Planning Application Ref: P/27/17/T

Location : 18 Boleyn Drive, Pagham

Description of works: 10m crown reduction of two Lombardy Poplars + 20% thin.

PLAN TO SHOW POSITION OF
2 LOMBARDY POPLAR TREES IN
REAR GARDEN OF 18 BOLEYN DRIVE,
PAGHAM, WEST SUSSEX.

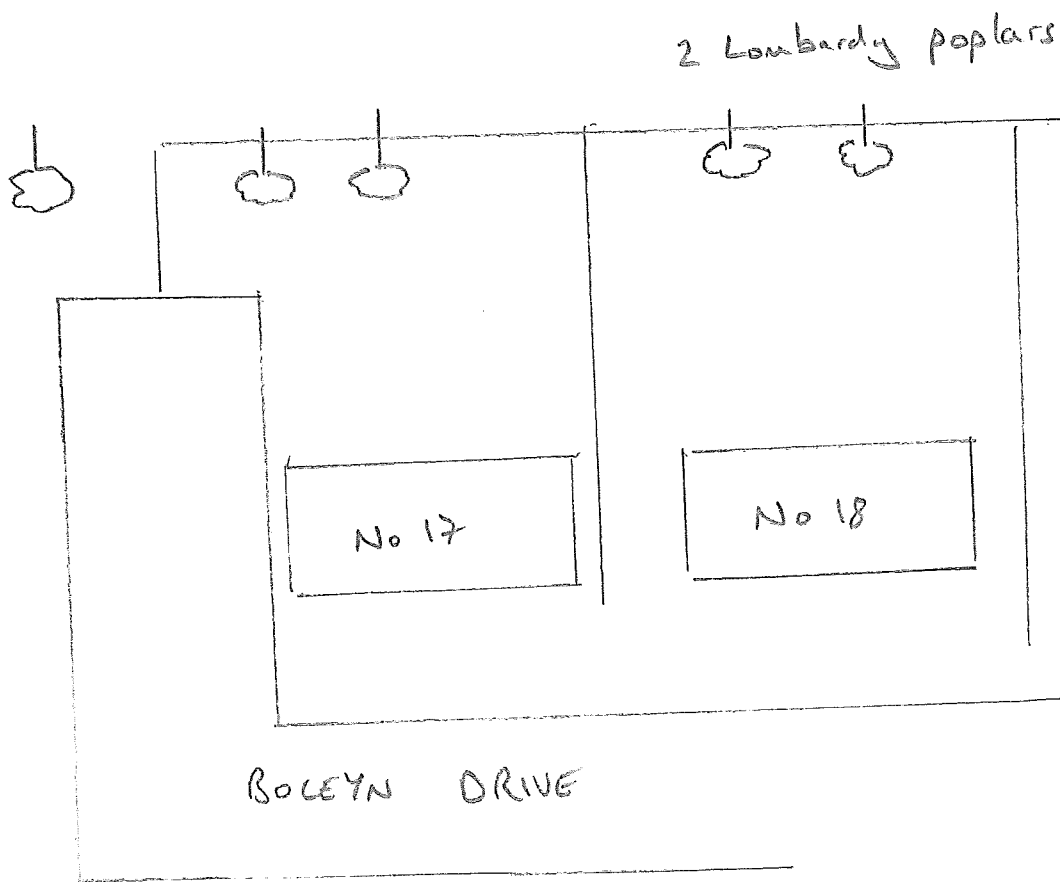
Lombardy Poplars *Populus nigra 'Italica'* Height: 12m AvgeSprd: 3m Age: Early mature

- Two trees that are sound and healthy and vigorous with significant growth potential.
- Given the size of the rear garden and proximity of these trees I can see why the applicants would want to constrain their growth potential.

- However, these trees are only 12m tall and the applicant has asked to reduce them by 10m which would leave a 2m stump.
- I have concerns over the extreme amount of pruning that has been requested which amounts to an 83% reduction when 30% is the maximum recommended under BS3998:2010 i.e. around 4m reduction from the tops.

- I also object to thinning of this type of tree when it will very quickly put this growth back on and in the interim this actually opens the centre of the tree up to wind pressures and makes matters worse increasing the risk of branch failures – also the new growth which is put back on will be denser than before so in two ways you make matters worse rather than better by thinning.

- These trees are visually significant in the landscape and the level of pruning needs to be less severe in nature – cutting at half height will leave a large open wound prone to fungal infection and decay which could in time result in cavities forming which undermine the integrity of the trees.

- I recommend **REFUSAL** of this application on the grounds that these are trees of high amenity value in the landscape and the level of pruning that has been requested is not only not justified but it has the potential to result in levels of damage that have a high probability of shortening the life expectancy of these trees.

- If the applicant chooses to come back in with an acceptable (in accordance with BS3998:2010 recommendations) level of pruning works then it would receive a favourable response.
